GREATER LONDON AUTHORITY

Deadline 3 - Sheet 4: GLA commentary on other documents prepared by the Applicant for Deadline 2

Appendix A Rev 0

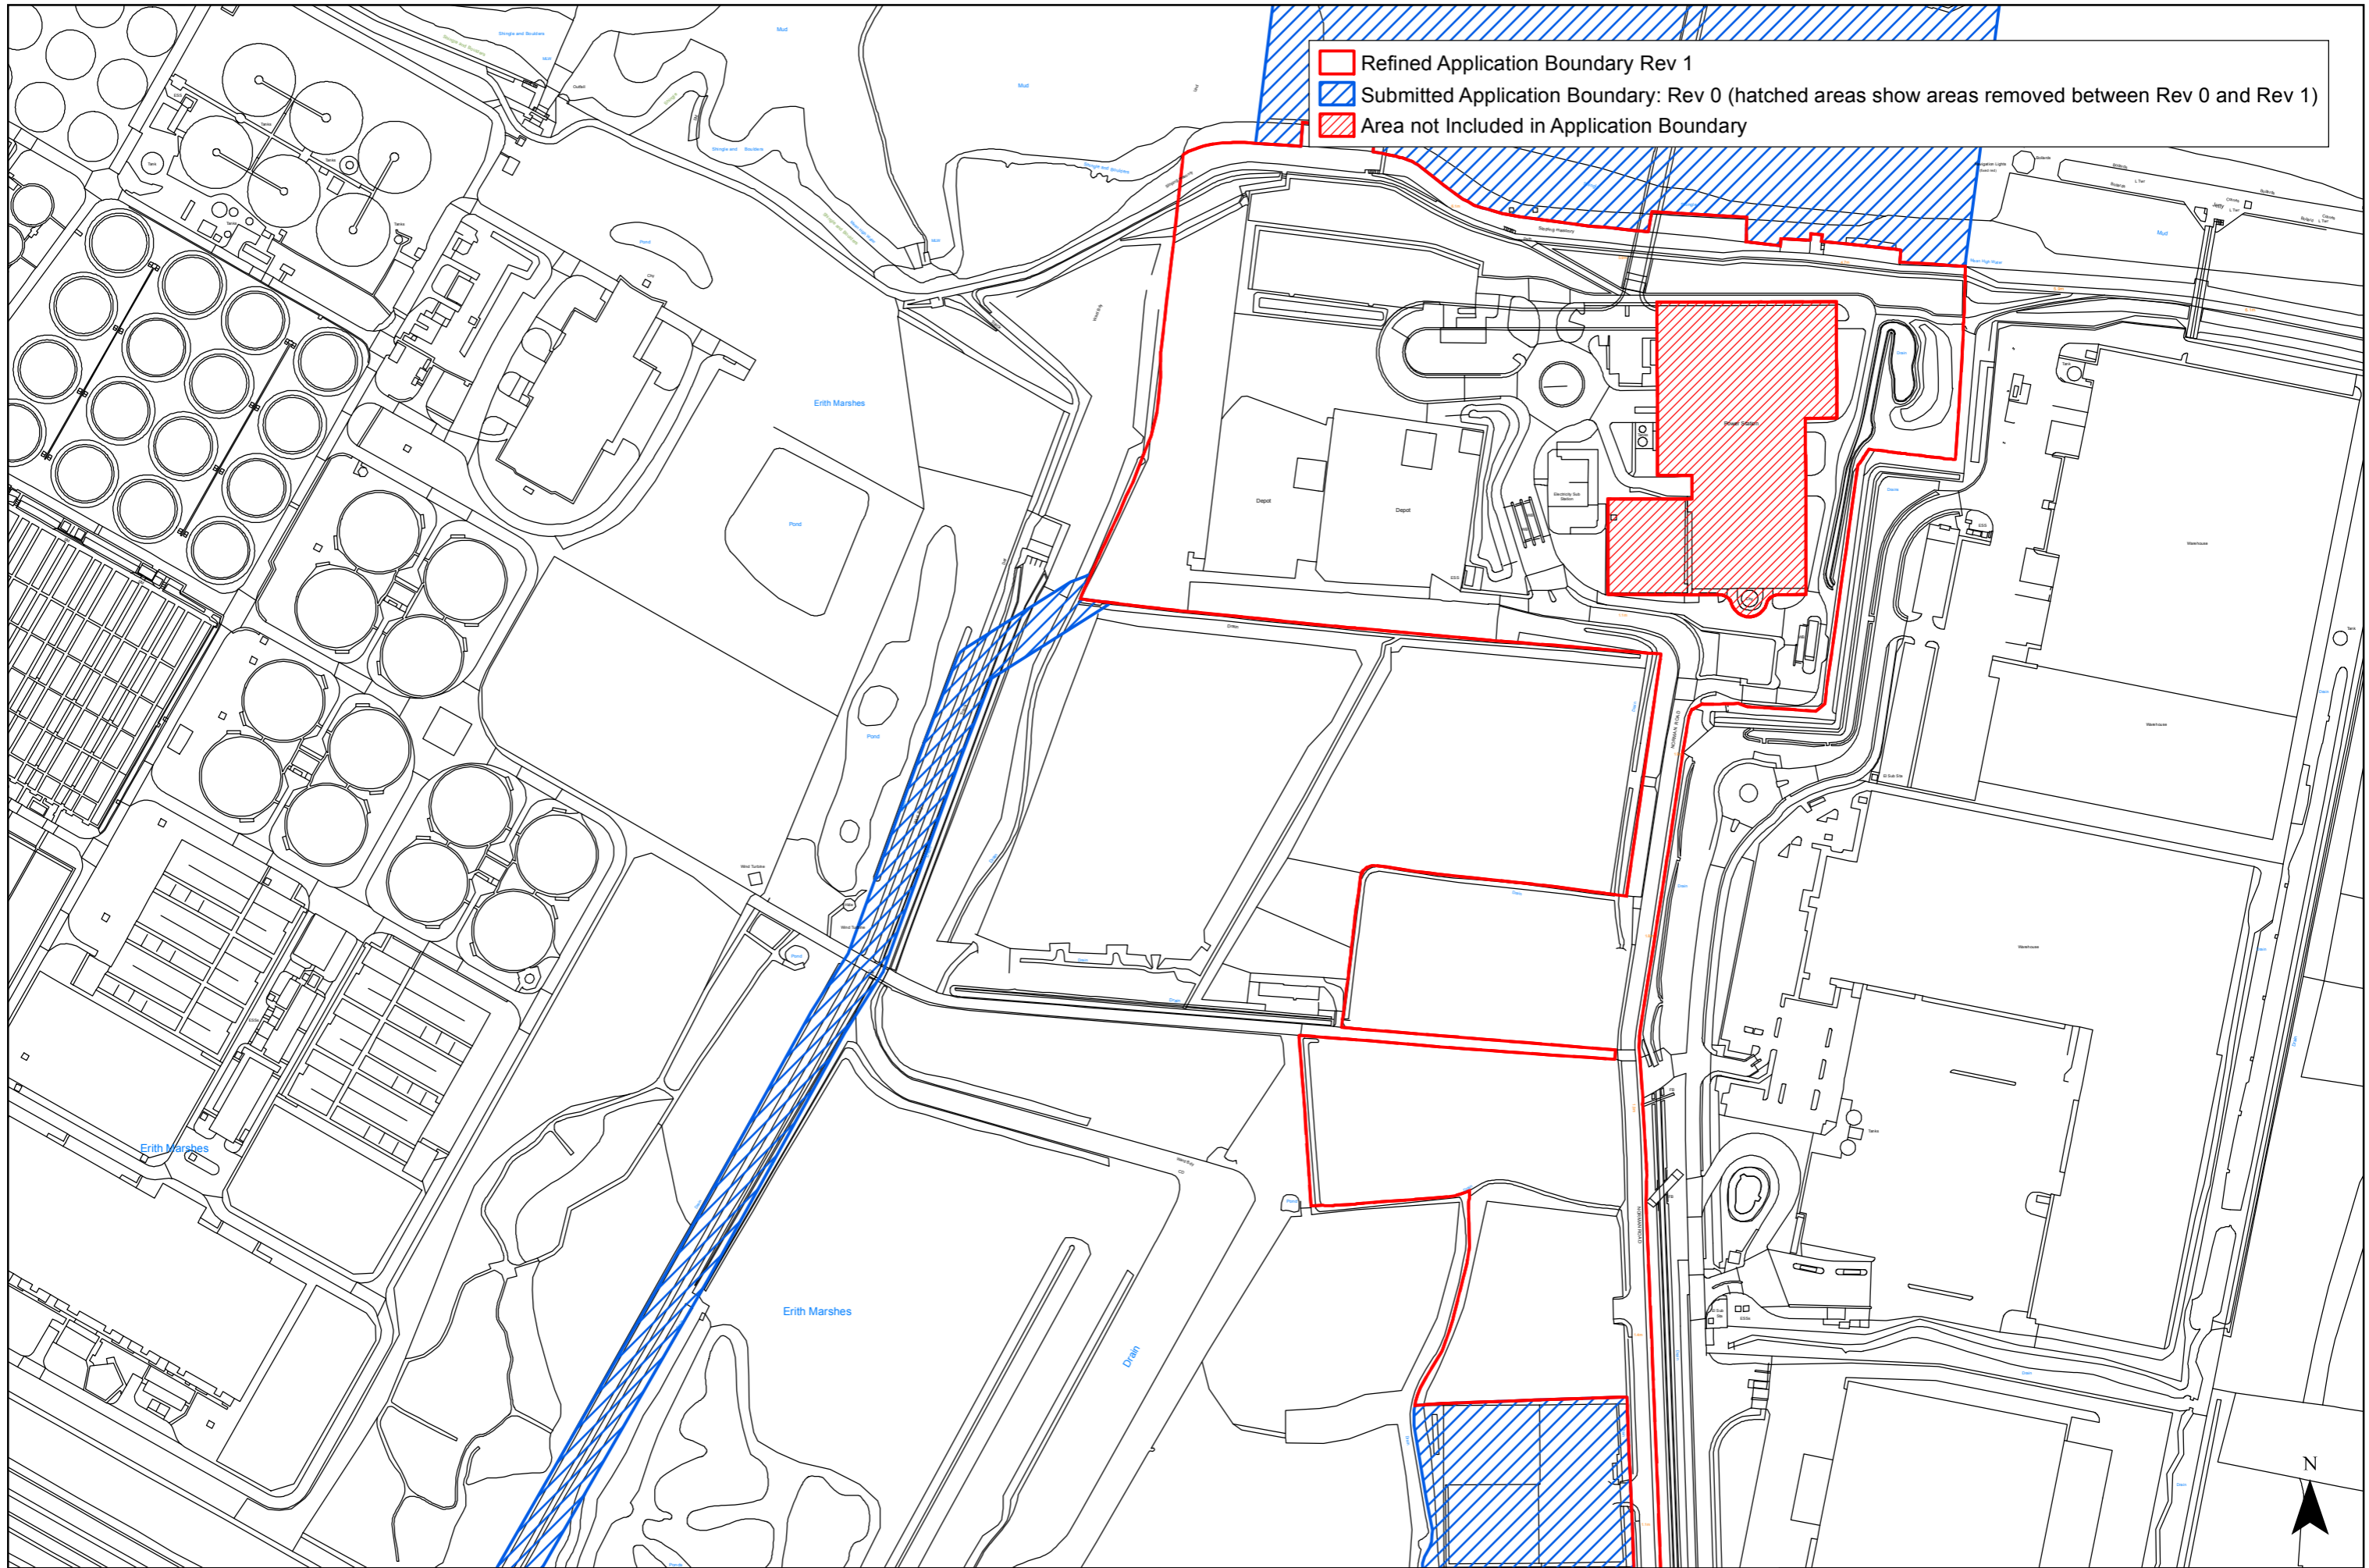
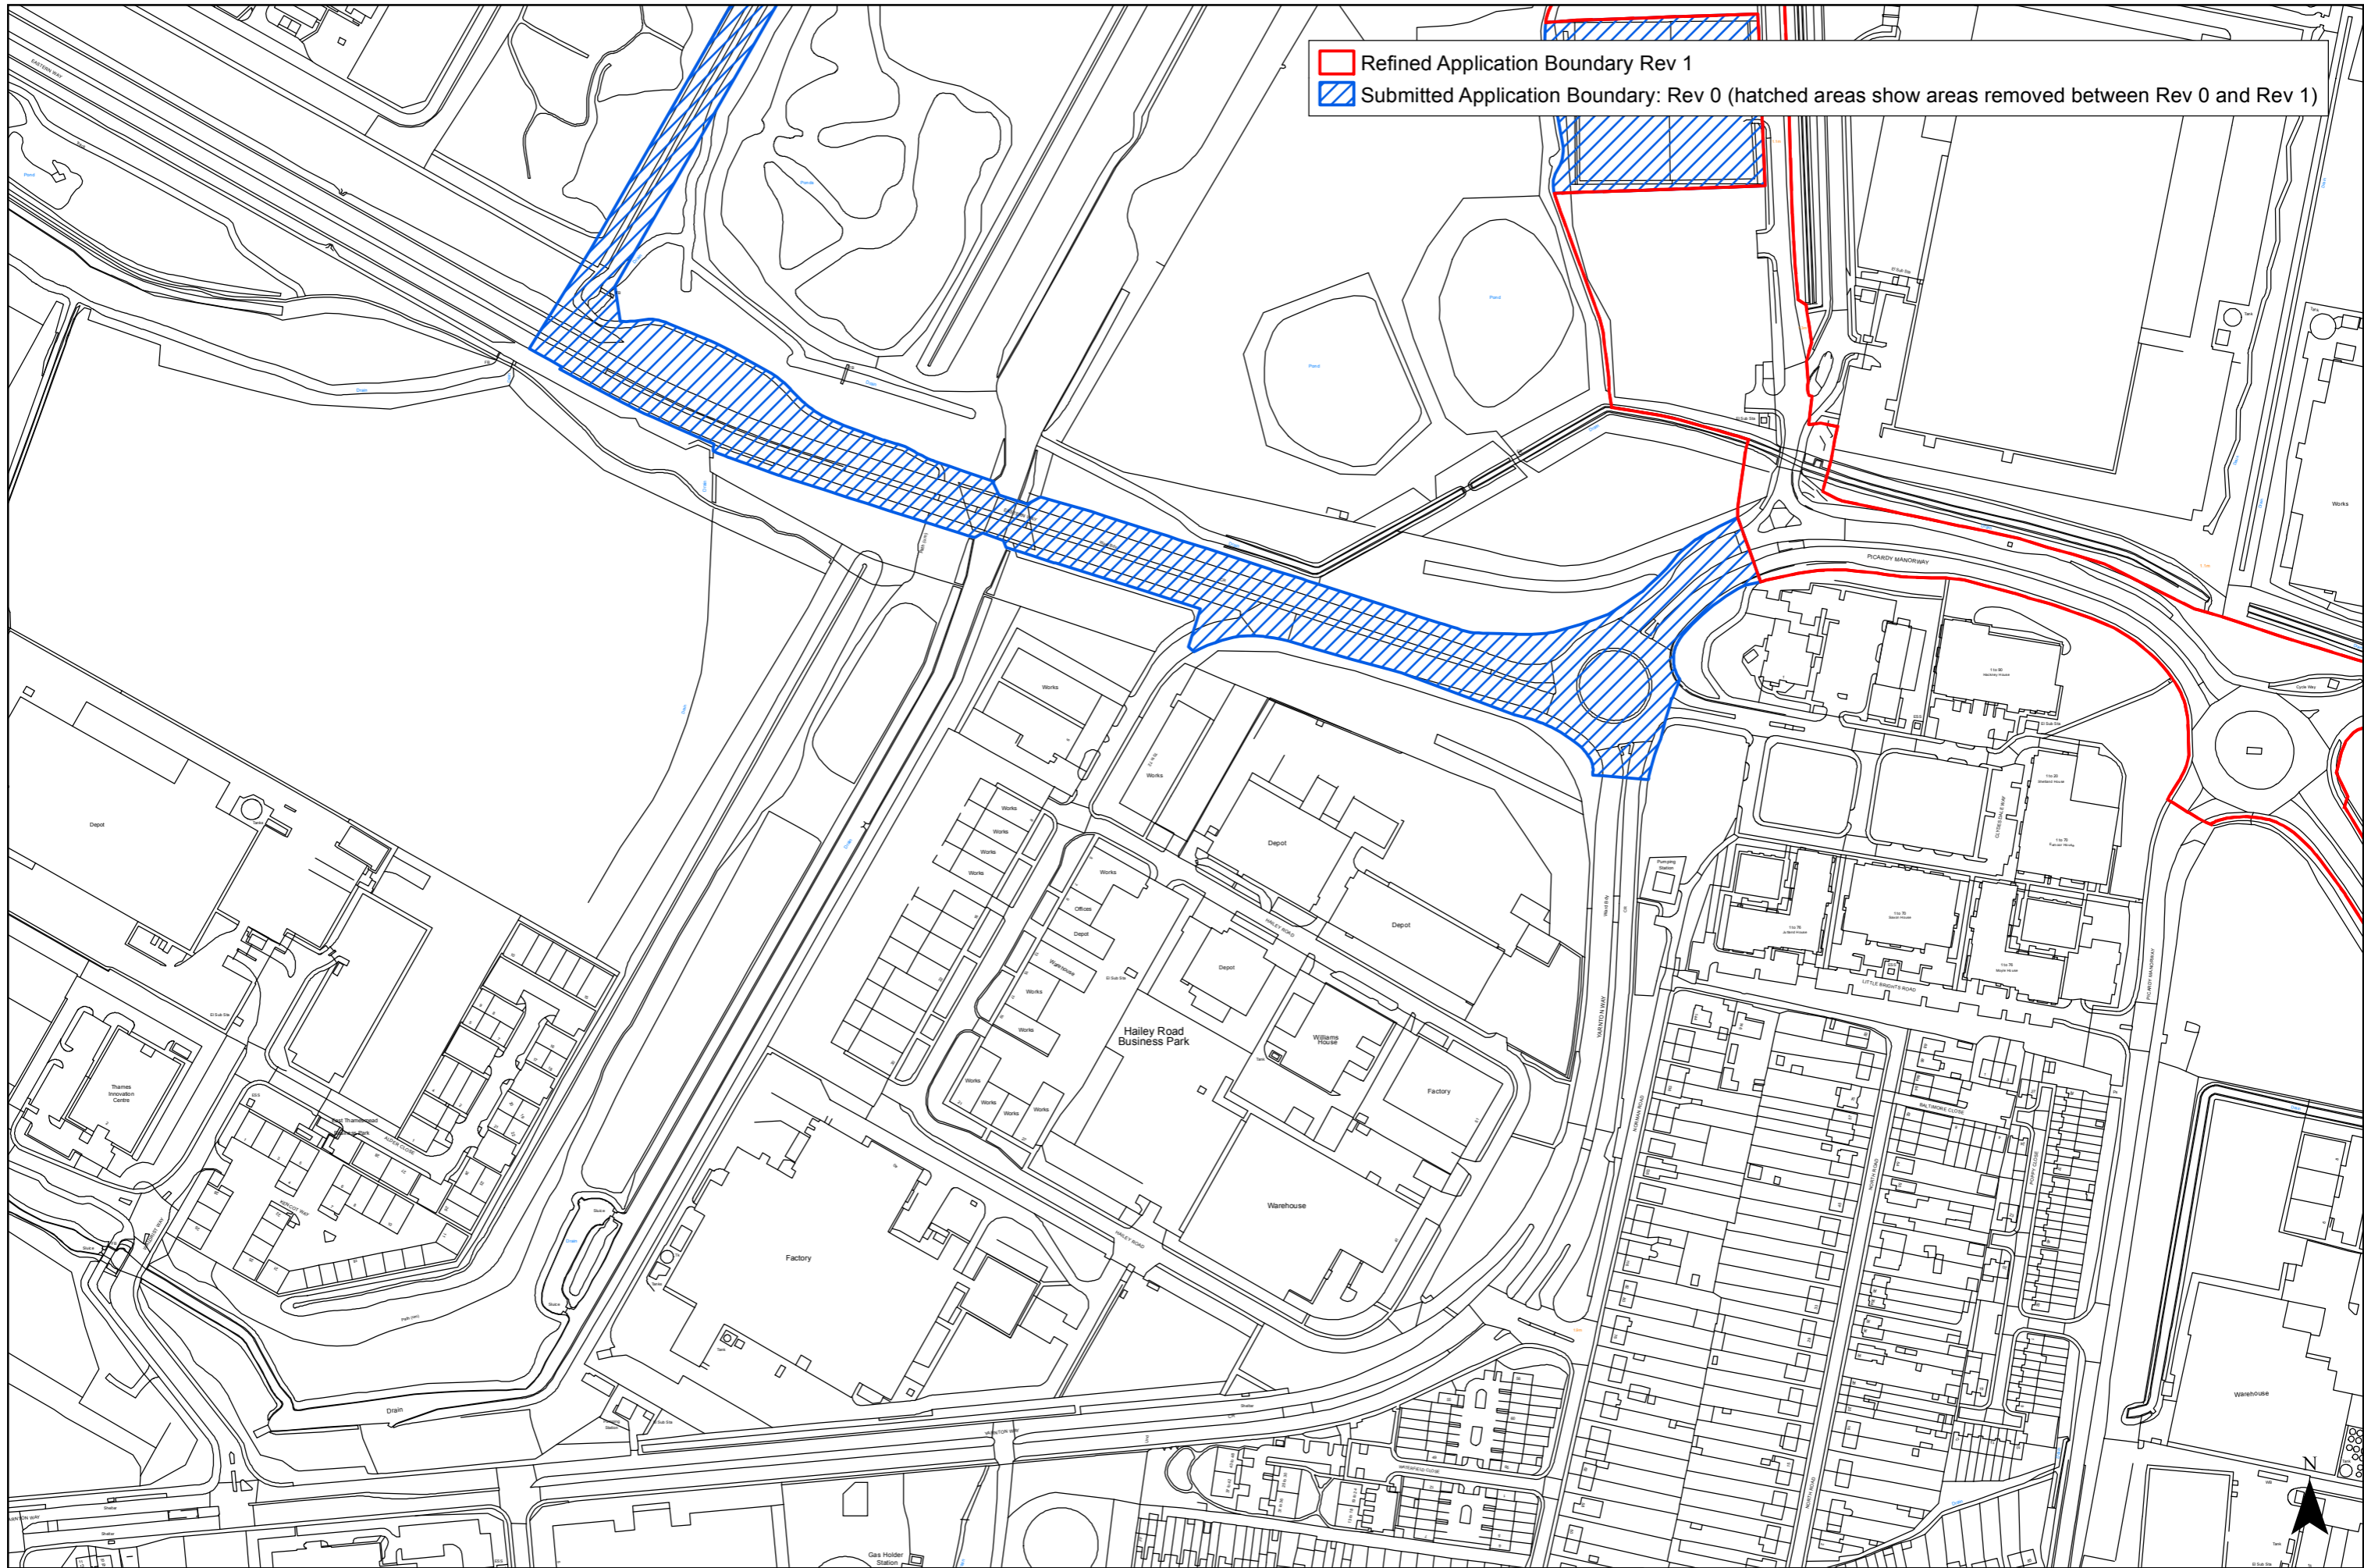
8.02.07 Electrical Connection Progress Report		
Connection route now selected	Additional assessment to determine quantifiable impacts of the Electrical Connection	The Applicant has set out the selected Electrical Connection route, which mostly follows the Strategic Road Network between the REP site and the Littlebrook Power Station. This route is expected to have a lesser impact on buses than the alternative route shown at the time of the submission of the application, however several bus routes will still be affected by the construction activities. This is set out visually in the figure below:

Item	Issue / action	GLA/TFL response
	<p>construction on buses.</p>	 <p>The map displays the River Thames flowing through the Bexley Heath area. A prominent yellow line, representing the 'ELECTRICAL CONNECTION', runs north-south through the center of the map. A network of red lines, representing 'BUS ROUTES', is overlaid on the map, showing various paths that cross the yellow line at several points. Key locations labeled include Bexley Heath, Erith, Crayford Marshes, and Rainham Marshes. A legend at the bottom of the map area identifies the yellow line as 'ELECTRICAL CONNECTION' and the red lines as 'BUS ROUTES'.</p> <p>The figure above shows that bus routes are expected to cross over the Electrical Connection route at several points via junctions and some bus routes would still run along the Electrical Connection</p>

Item	Issue / action	GLA/TFL response
		route. The impact of construction on these routes should be fully assessed by the applicant so that TFL and bus operating companies are able to propose mitigation based on the likely level of delay to the bus routes.
